Our reference: R/2021/10/A

Your reference: SSD 32927319

Subject: Advice on EIS - Powerhouse Ultimo Renewal - Stage 1 - SSD 32927319

Figure 11.20 Turbine Hall Grading of Significance (Level 3) (Source: John Wardle Architects plan with Curio Projects overlay

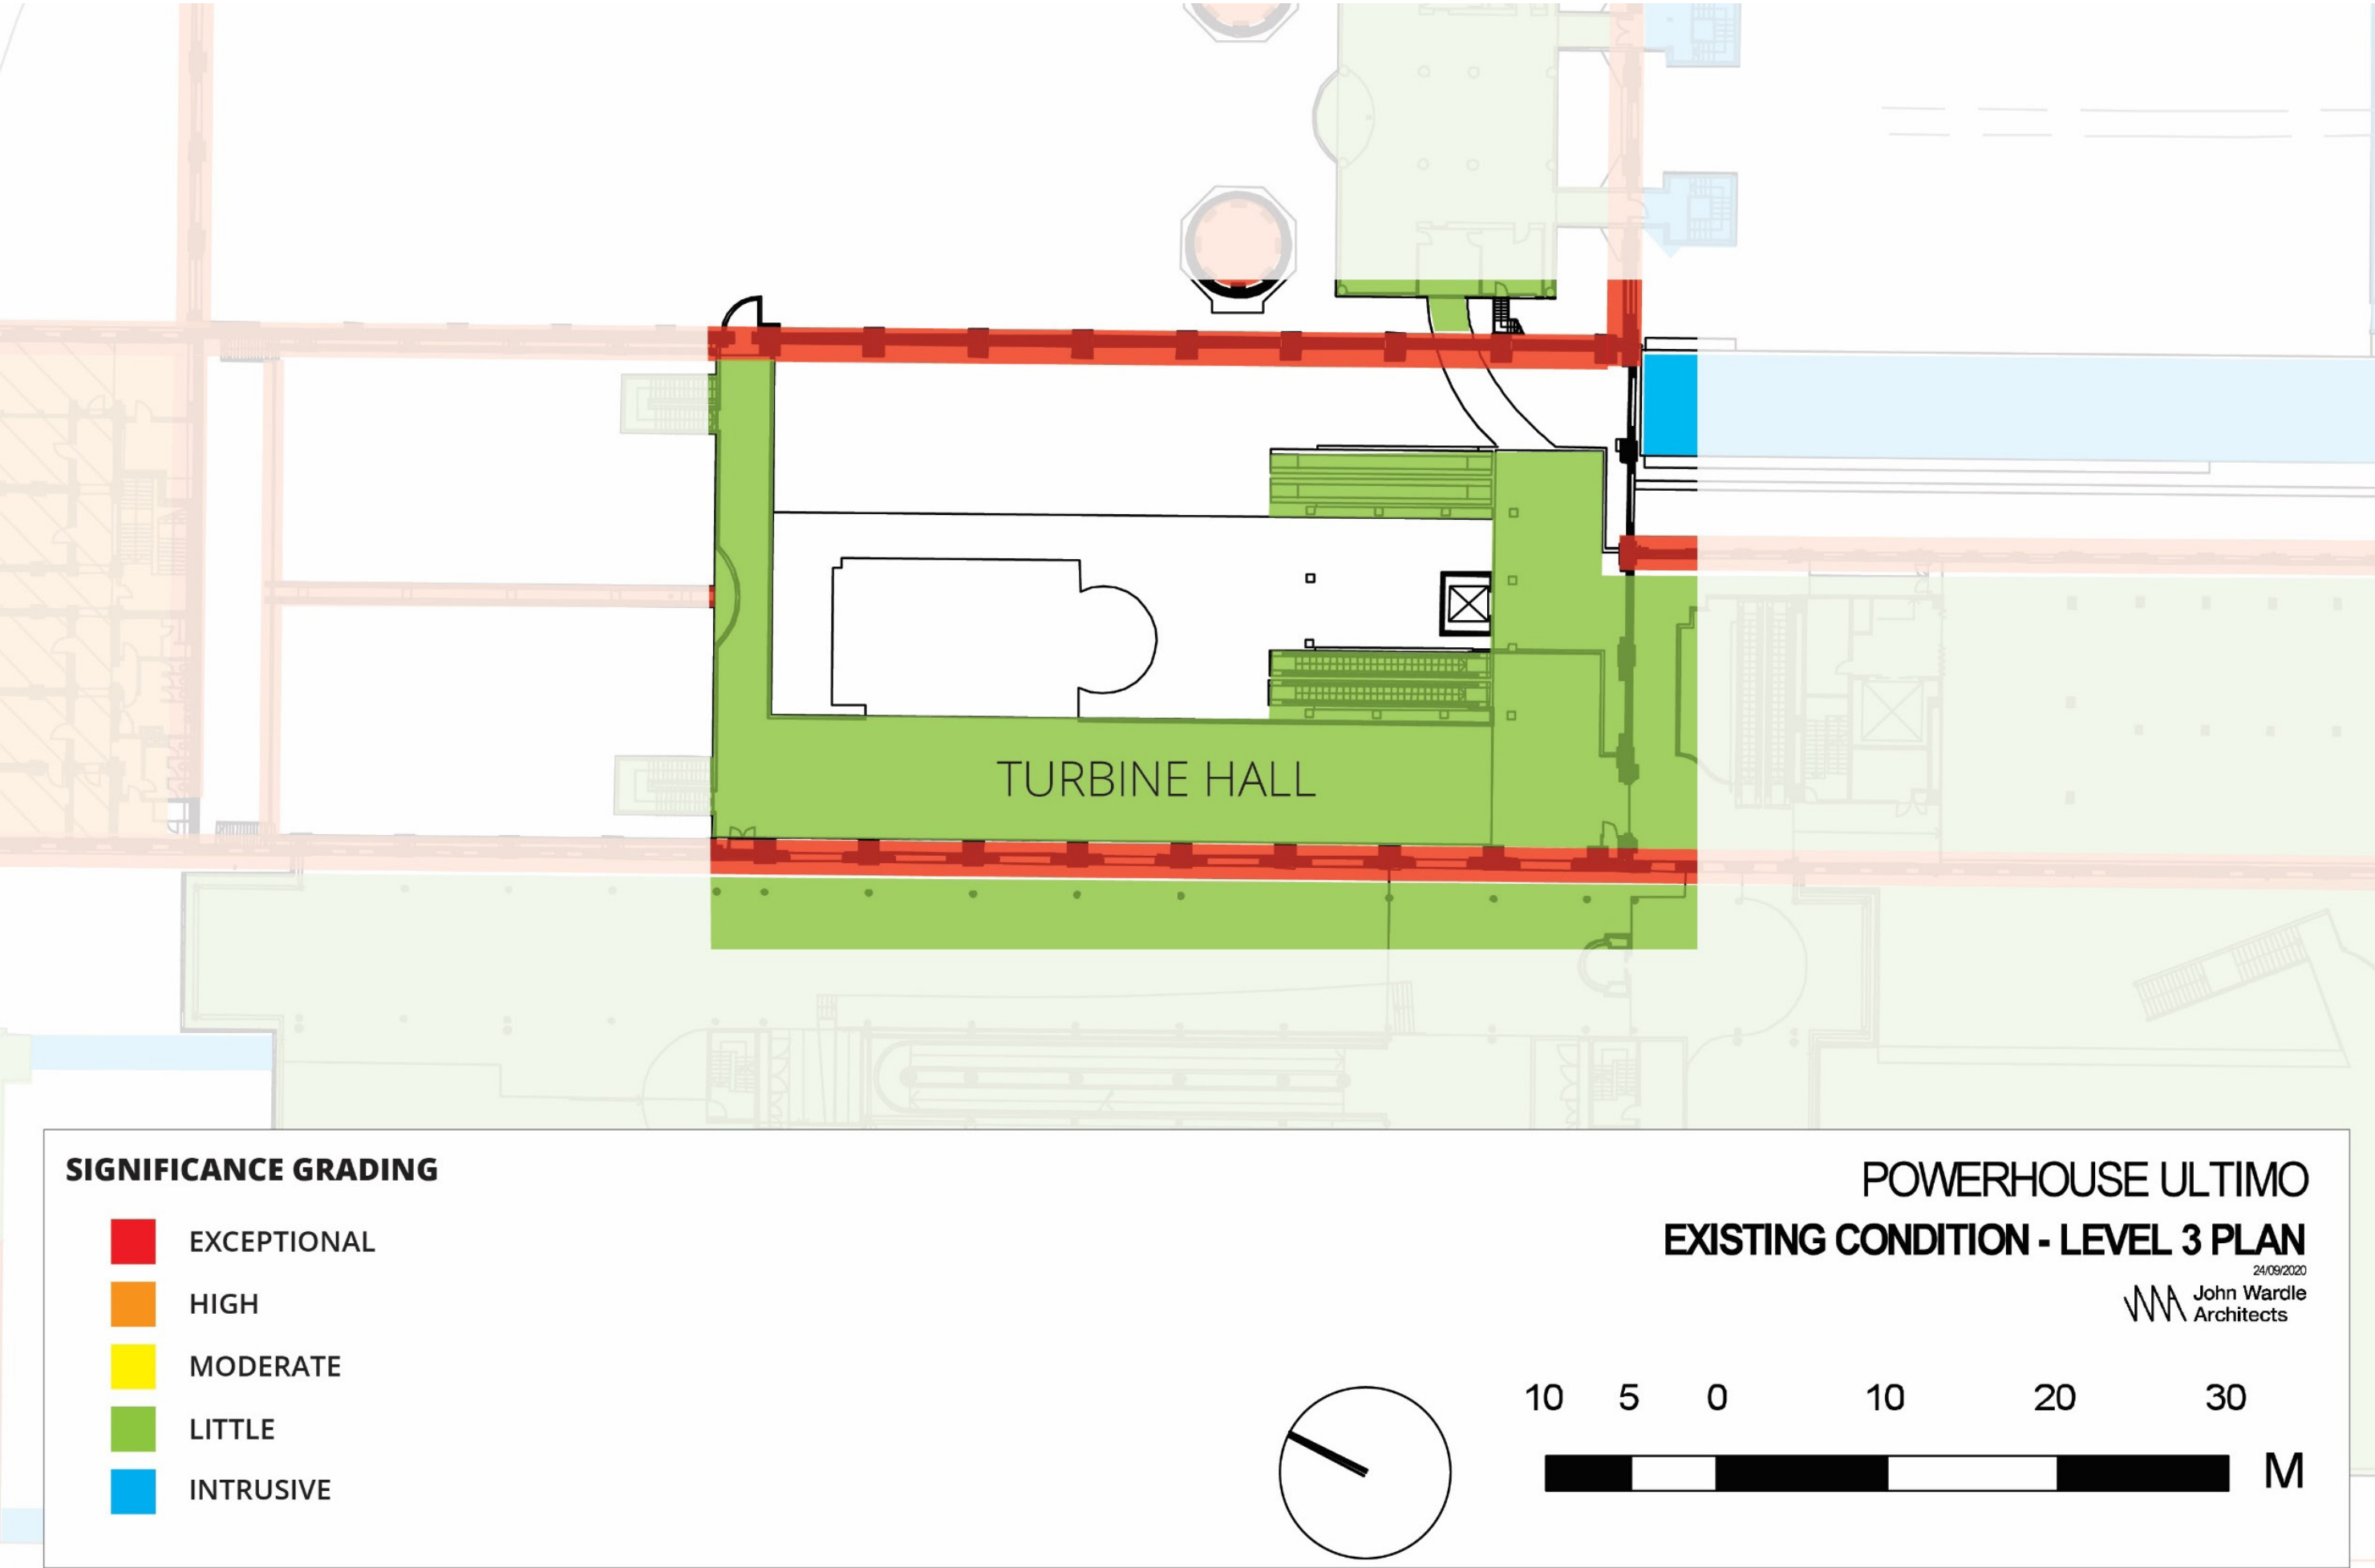
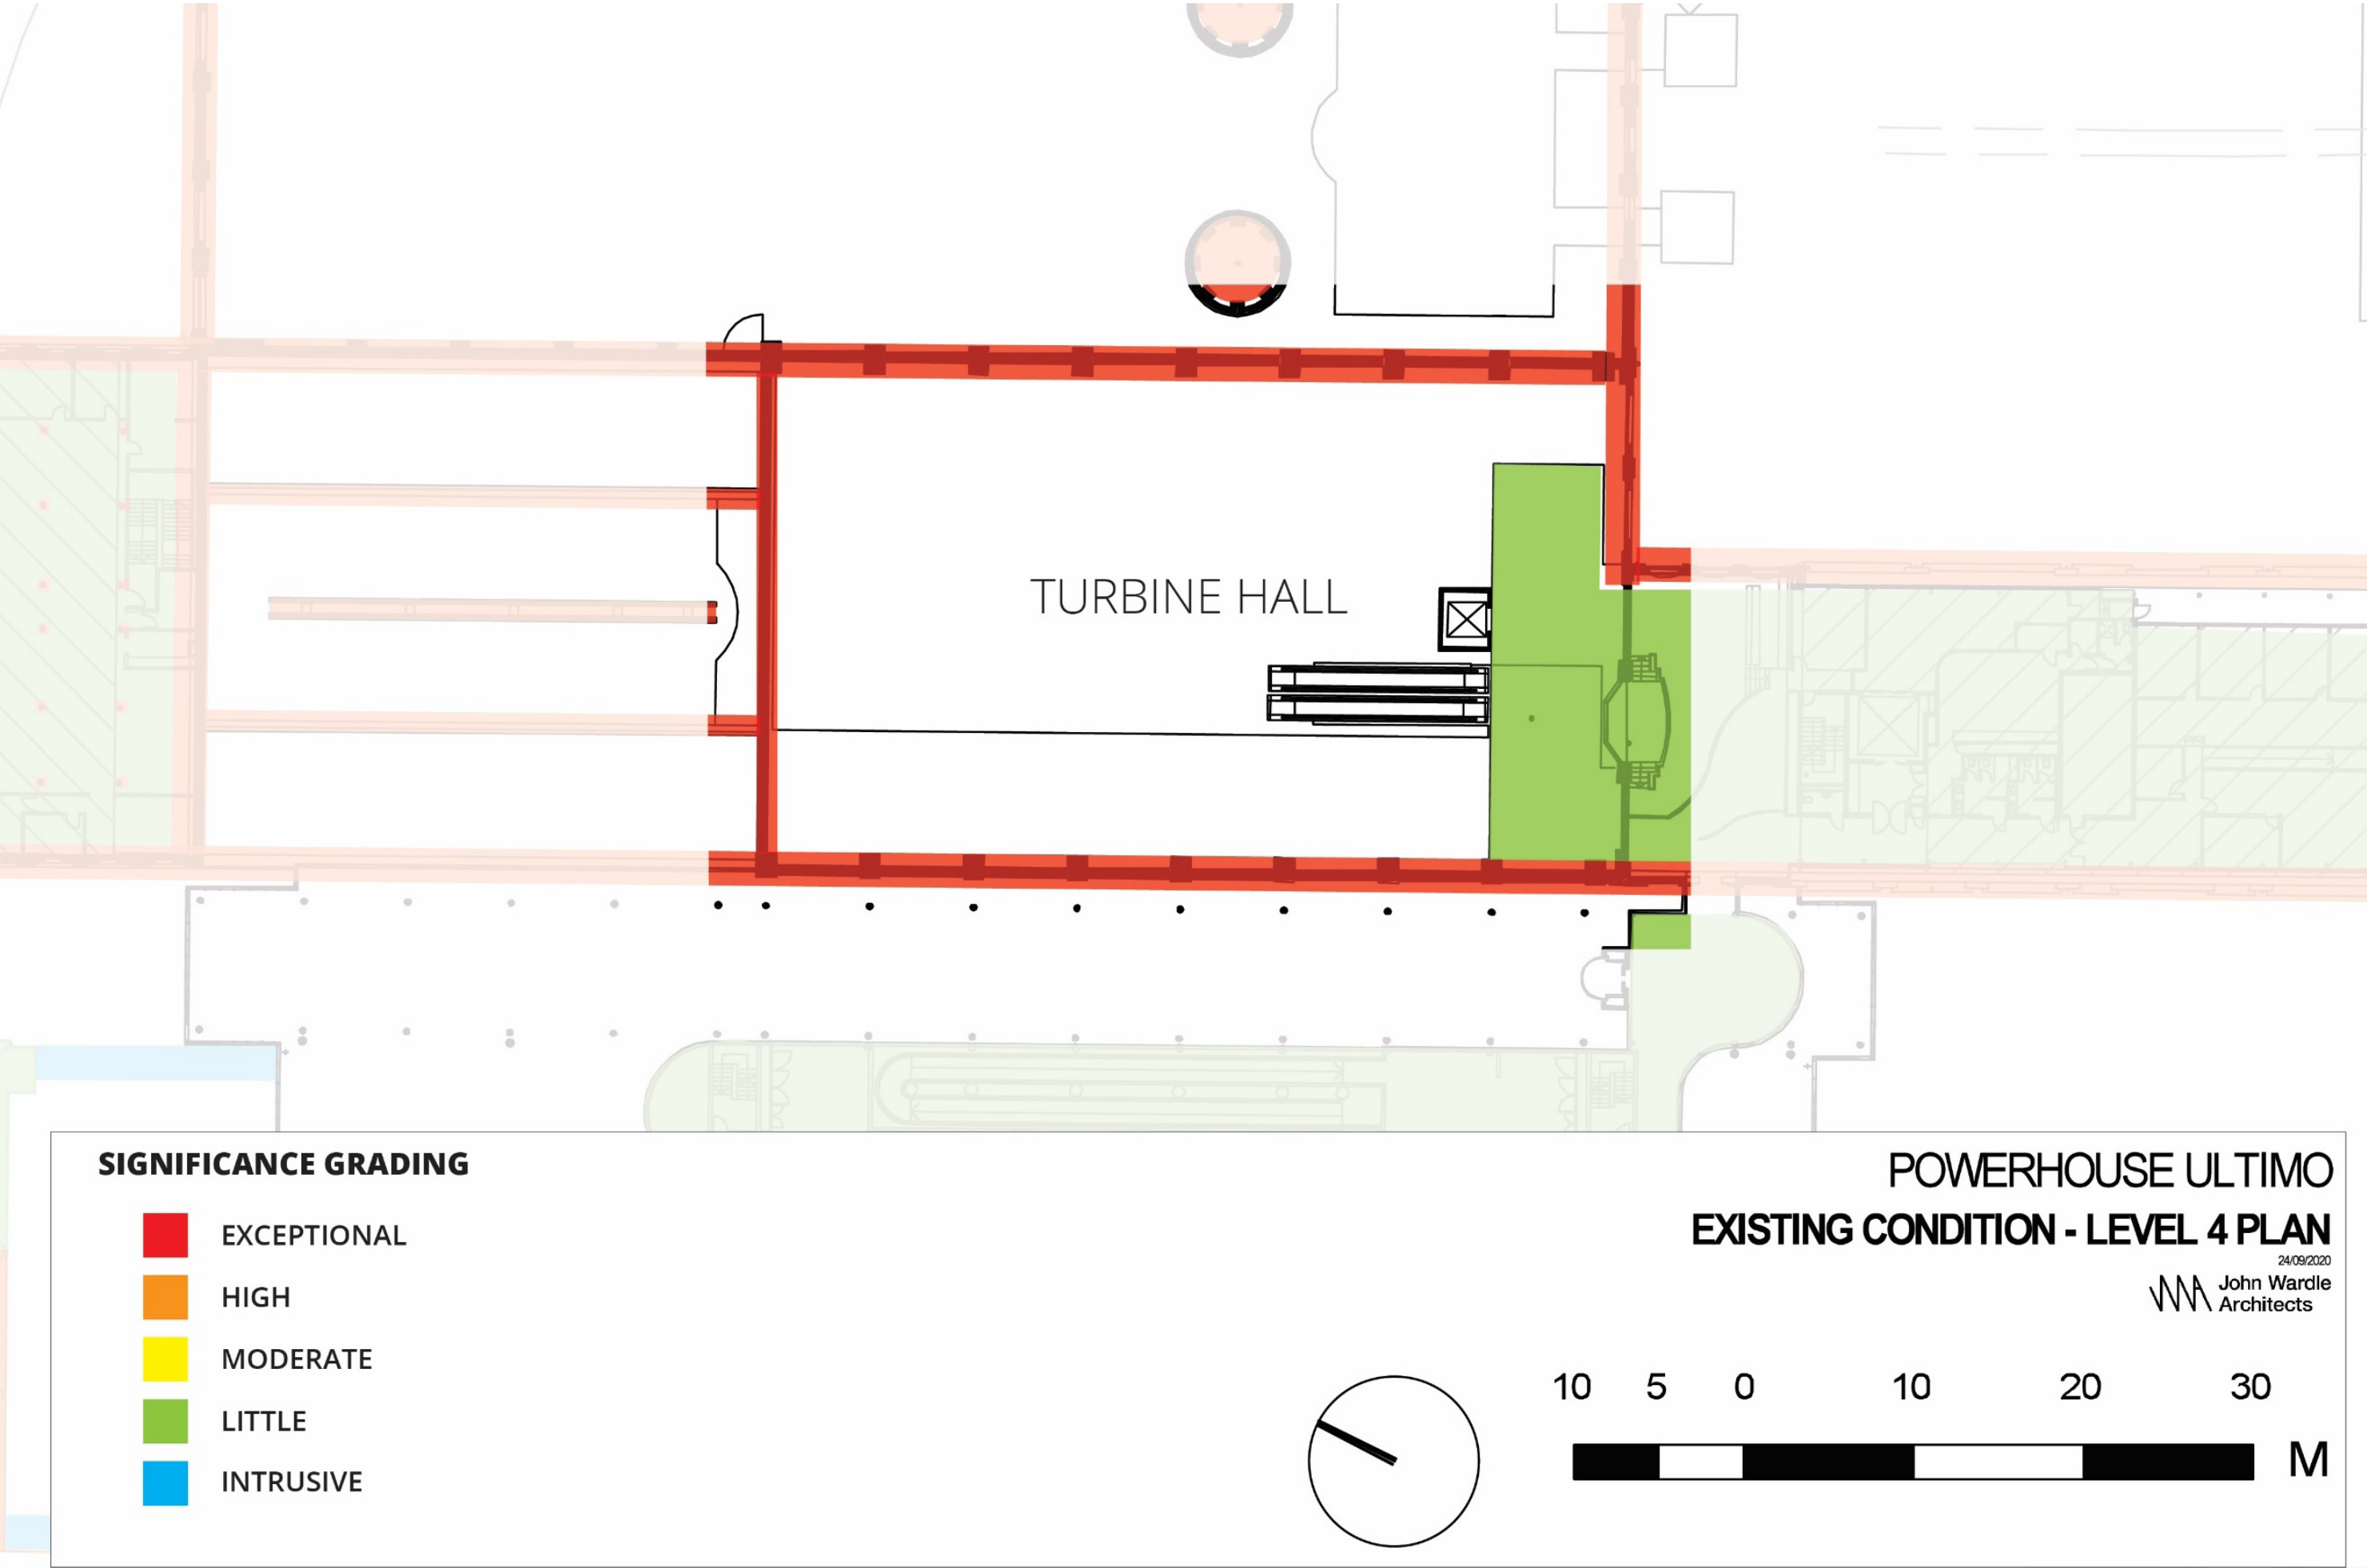
- Section 4.4 Heritage curtilage and Section 4.5 do not comprise a sufficient curtilage analysis.
- Sections 4.6 Gradings of significance – The plans representing the gradings in Part C should be consolidated into Part 4.6, as one single detailed plan of the site. The plans in Part C are too large to be legible. At present the plans in part C are too fragmented to be readily located. The grading of significance should evaluate the buildings in 3 dimensions, represented in sections and elevations of the buildings to pick up elevation detail, roof forms, internal structural elements, fabric and components such as gantries. The roof plans should identify all the distinctive roof forms such as lanterns and chimneys.
